Reference: Tree Protection Guidelines and Response to Corrections

Date: May 23, 2023

Site Address: 9167 SE 64th, Mercer Island 98040

Parcel: 3024059151

**APN: 302405-9151
 COVER SHEET
 ALTMAN PARCEL B
 MERCER ISLAND, WASHINGTON**

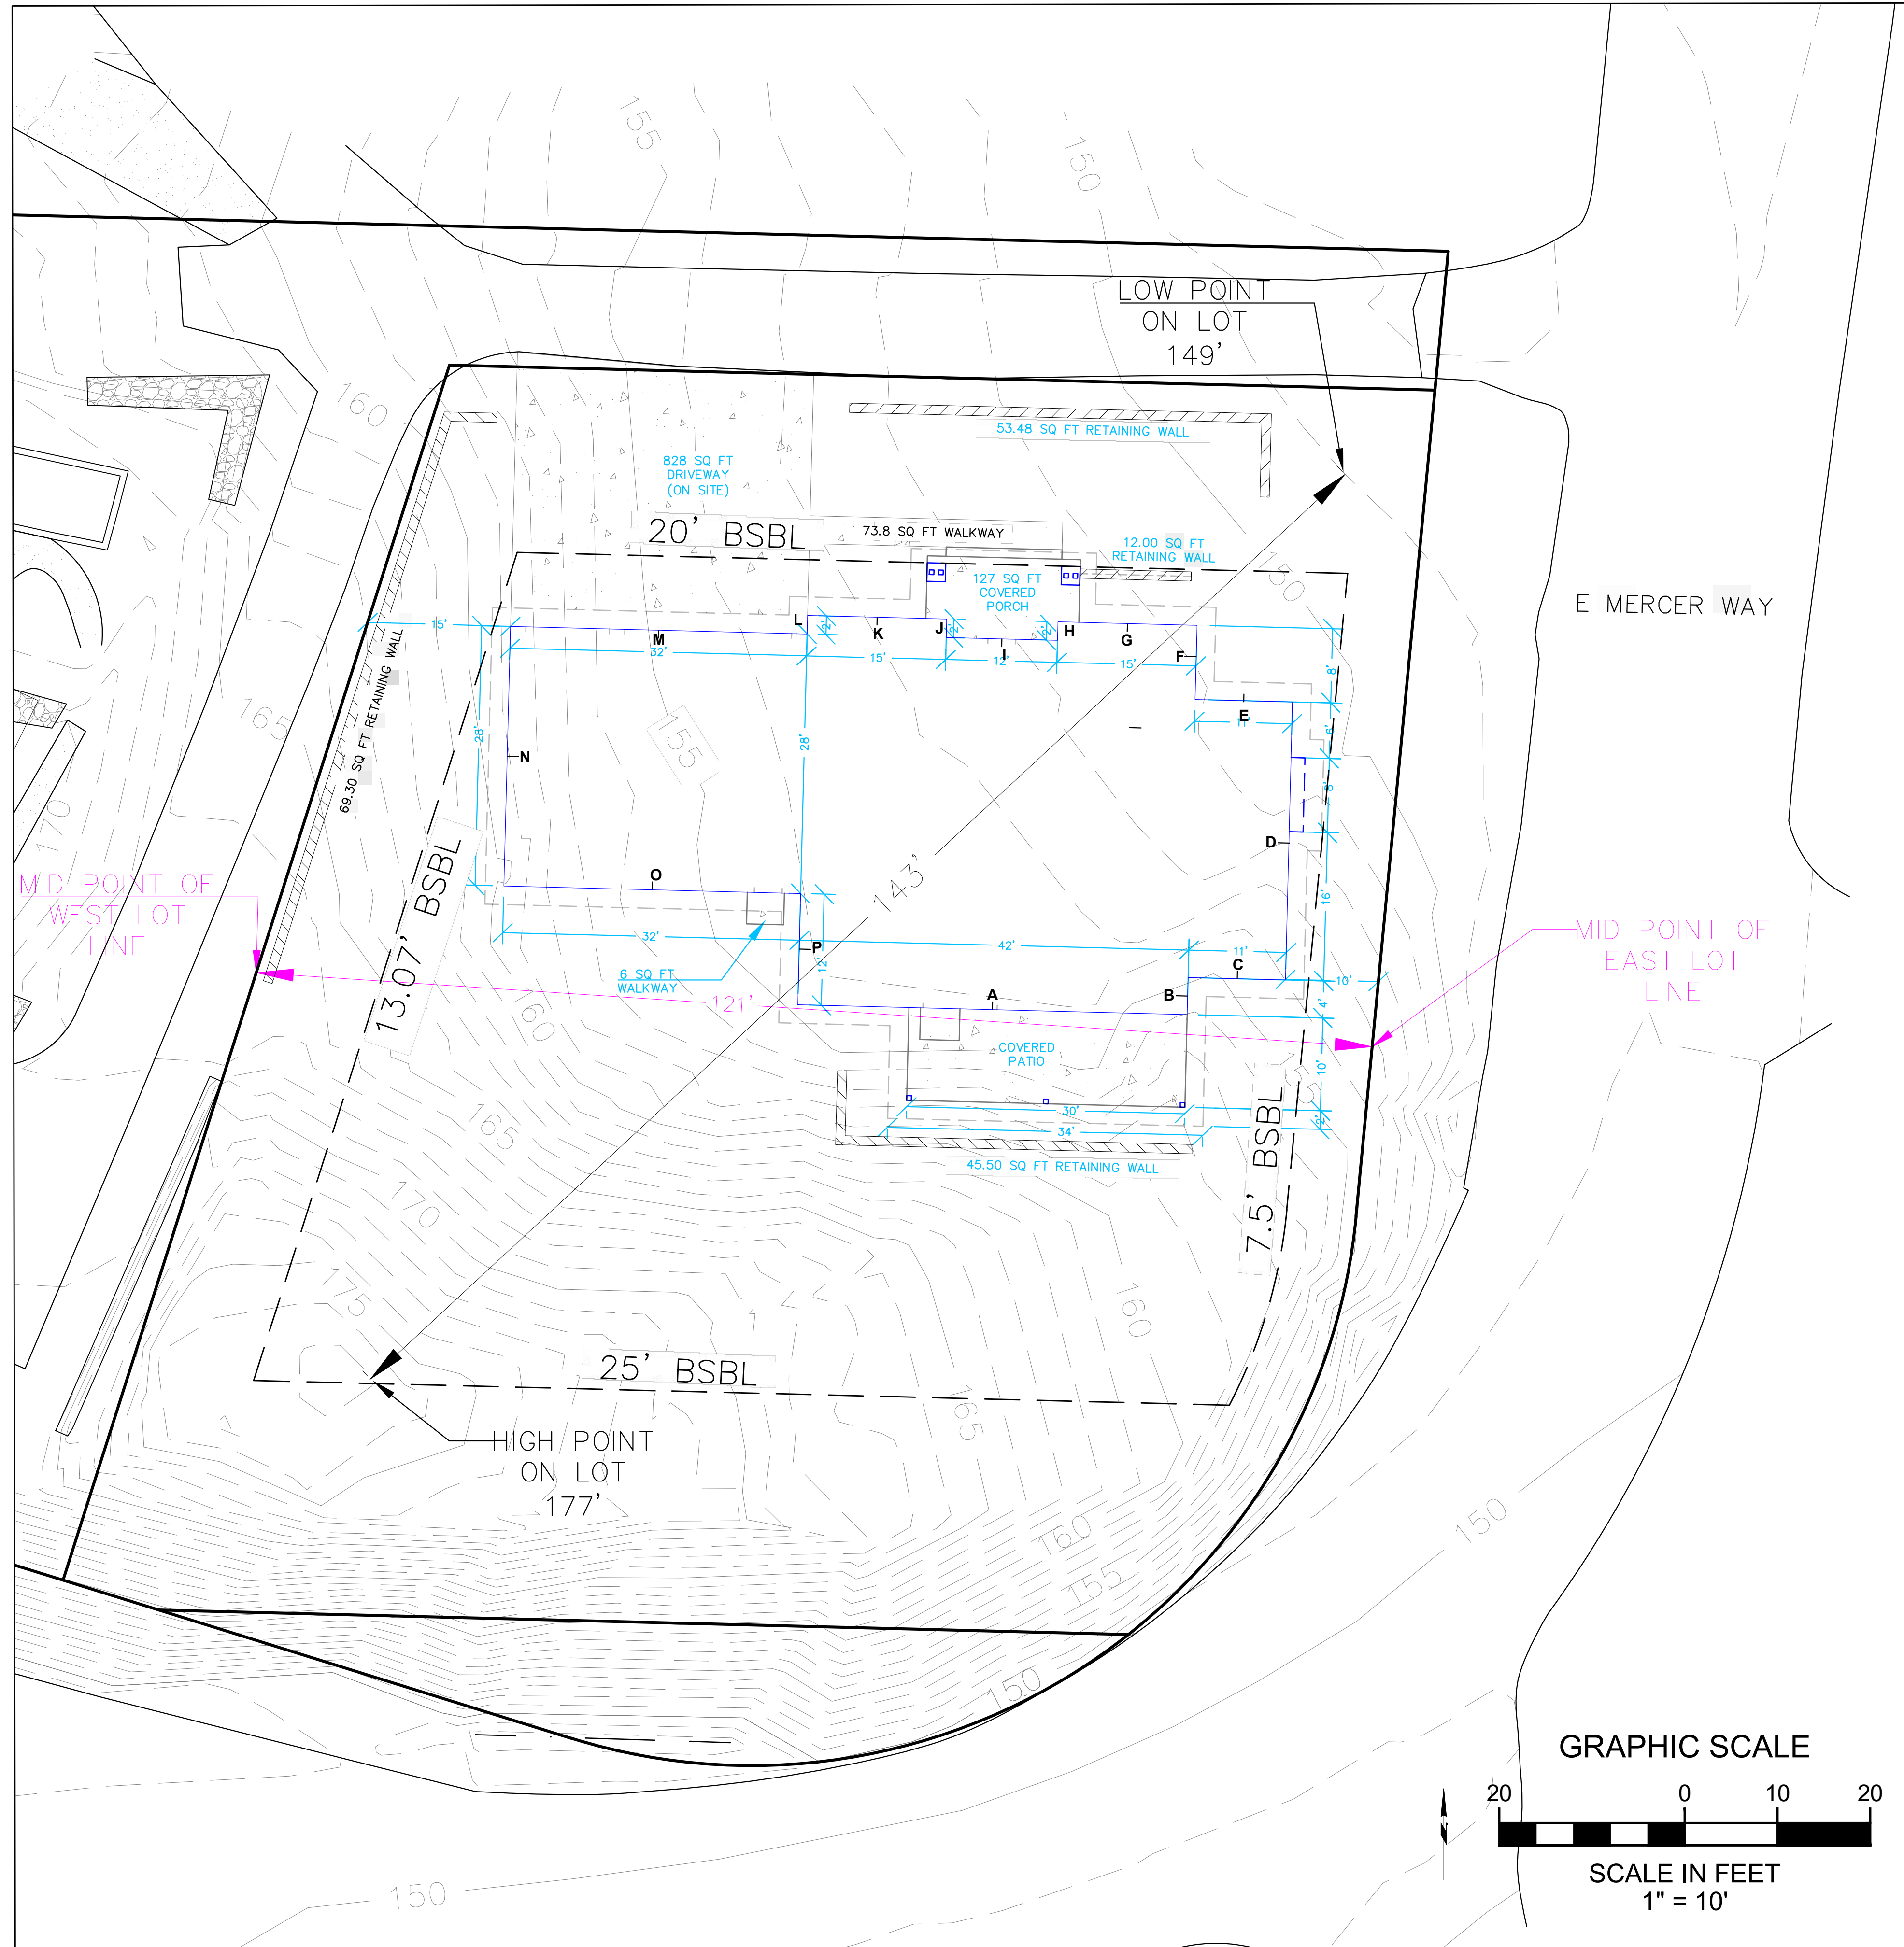
4. (for civil) Show all trees and tree protection on sheet 3 of 5. See checklist for the tree protection plan that must be followed

Tree protection fencing: A six-foot temporary chain-link fence or approved orange polyurethane equivalent shall be installed outside the driplines of all retained trees, as indicated on the annotated illustration in this report. All site plans shall be updated accordingly. Fencing shall be installed before any site disturbance, demolition or construction, and after tree removal and pruning for clearance is complete. The project arborist or a city planner shall approve fencing material and placement prior to demolition or construction. Any modifications to tree protection measures shall be approved by the project arborist or a city planner.
